**STATE SIGNIFICANT DEVELOPMENT APPLICATION – SSD 5752  
SYDNEY INTERNATIONAL CONVENTION, EXHIBITION AND ENTERTAINMENT PRECINCT  
(SICEEP)**

**STATE SIGNIFICANT DEVELOPMENT APPLICATION – SSD 5752  
SYDNEY INTERNATIONAL CONVENTION, EXHIBITION AND ENTERTAINMENT PRECINCT  
(SICEEP)**

DFP has been commissioned by Suntrack Holdings Pty Limited ("SH"), the owners of the Harbourside Shopping Centre, Darling Harbour, to review the State Significant Development Application for the redevelopment of the Sydney Convention and Exhibition Centre and Entertainment Centre and associated public domain works. The submission is prepared in response to the public exhibition of the development application.

SCALE @ A1 1 : 500	DRAWN RD	DESIGNED -	REVIEWED JH	APPROVED GI
PROJECT NUMBER AA004399	DRAWING NUMBER PP-CI-0022	REV A

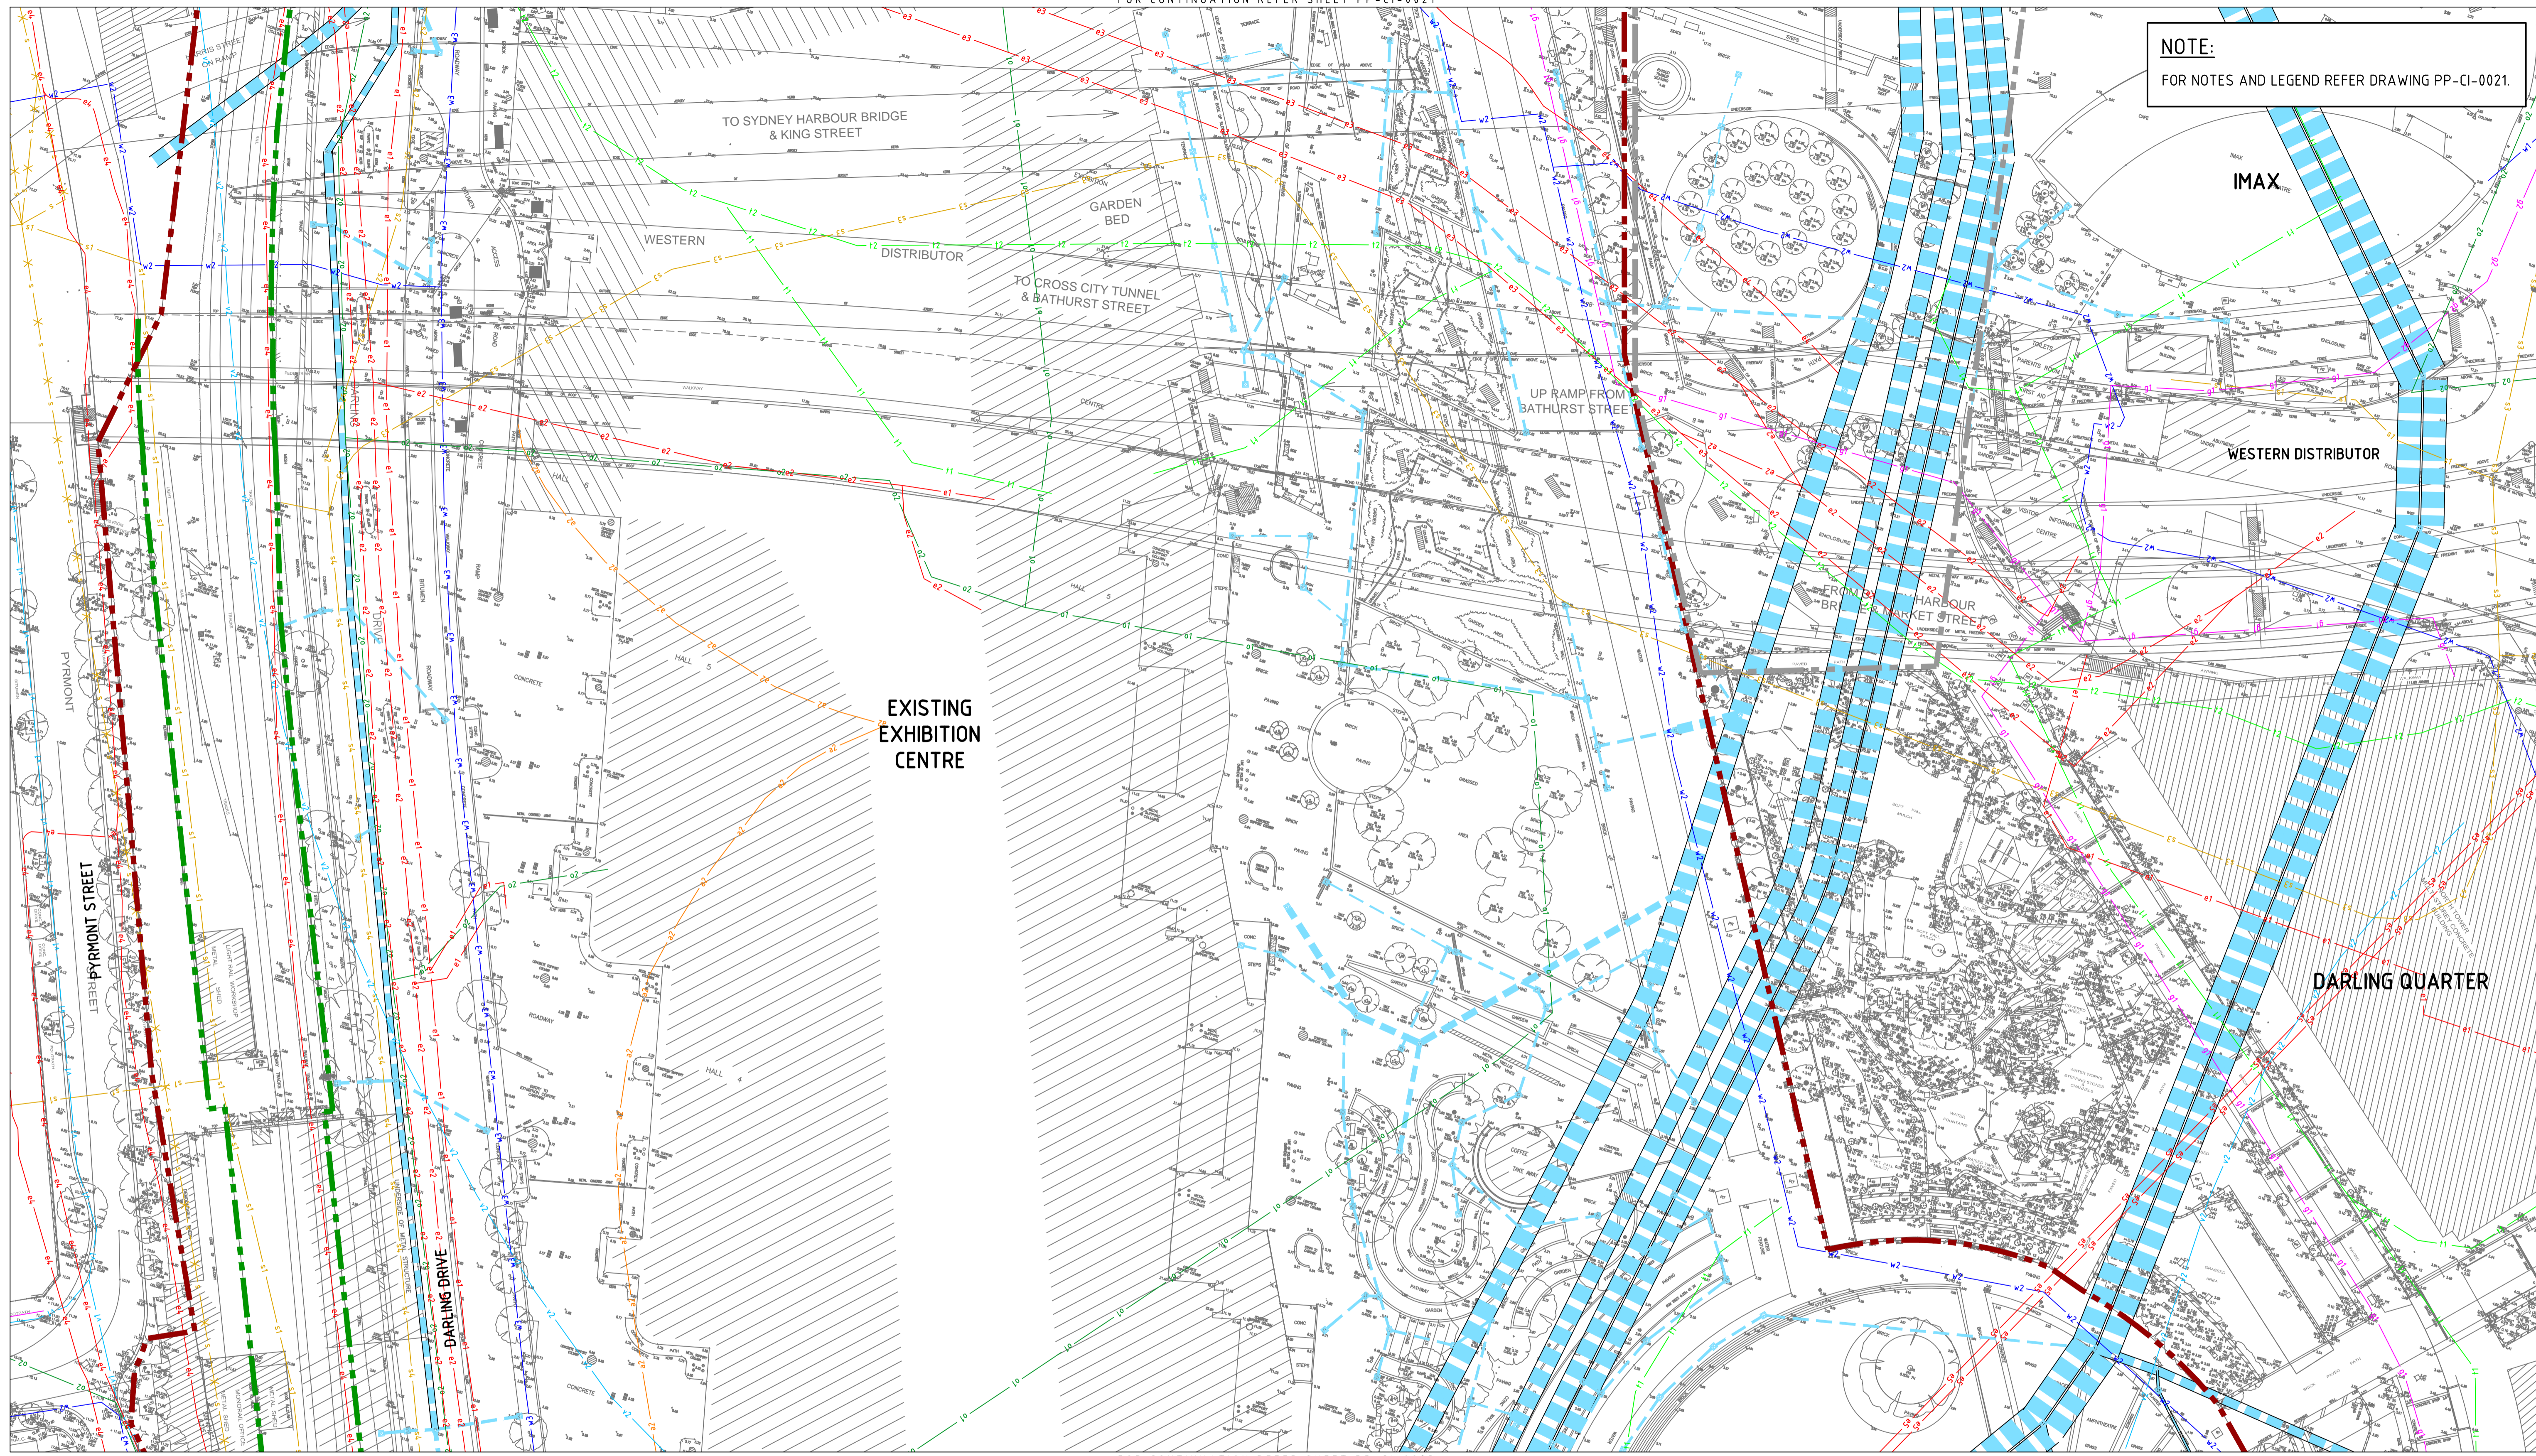
The design of Harbourside Place is not encapsulated in a single legible drawing, but detailed in part on several drawings including the Civil Works Plan, Pavement Plan and Landscape Plan. The drawings illustrate six car spaces for drop-off. This suggests there will be only potential for three spaces available for taxi's, with the remaining area to be used by one coach (as illustrated on drawing PP\_LA\_201). These same spaces are also identified as the VIP drop-off point creating a conflict in use and an unrealistic expectation of the demand during normal usage as well as peak events. We note that the survey of usage in the current loop road included a peak demand of 293 taxis in a 1 hour period<sup>6</sup>.

Based on the current arrangements with the loop road off Darling Drive in front of HDH and the frequency of use, the proposed design of Harbourside Place does not provide sufficient space for taxi, hire car and coach parking that will be required to efficiently and effectively service the expanded convention and exhibition centre, the proposed ICC Hotel or the existing HDH. At a minimum Harbourside Place should be designed based on the current level of spaces provided.

Given the likely high level of vehicular activity Harbourside Place should be designed to minimise pedestrian and vehicular conflict. The proposed design may be noted as a pedestrian share way, however there are changes to the paving to denote vehicle paths, and the primary pedestrian route crosses the vehicle paths at multiple locations putting pedestrians at an unnecessary risk of being struck by a vehicle (refer to **Attachment 4** to this submission - Drawing No MP9125).

It is requested that the current design of Harbourside Place not be approved and that an alternative design be prepared that:

- Provides at least the same number of vehicle bays and level of convenience from those bays to the surrounding facilities, and for the bays to be calculated solely on the number of vehicle bays located to the east of Darling Drive;
- Maintains the current kerbside drop-off/pick-up area directly in front of the HDH;
- Provides a through link connection from the roundabout to the proposed Harbourside Place and Darling Drive along the western boundary of HDH;
- Provides separate and adequate spaces for coaches, taxis and hire cars;
- Is designed to clearly delineate pedestrian and vehicular areas;
- Allows for emergency vehicle access to the western side of the HDH both during construction and upon completion;
- Provides adequate setback to facilitate current fire engineered solutions and egress from HDH; and
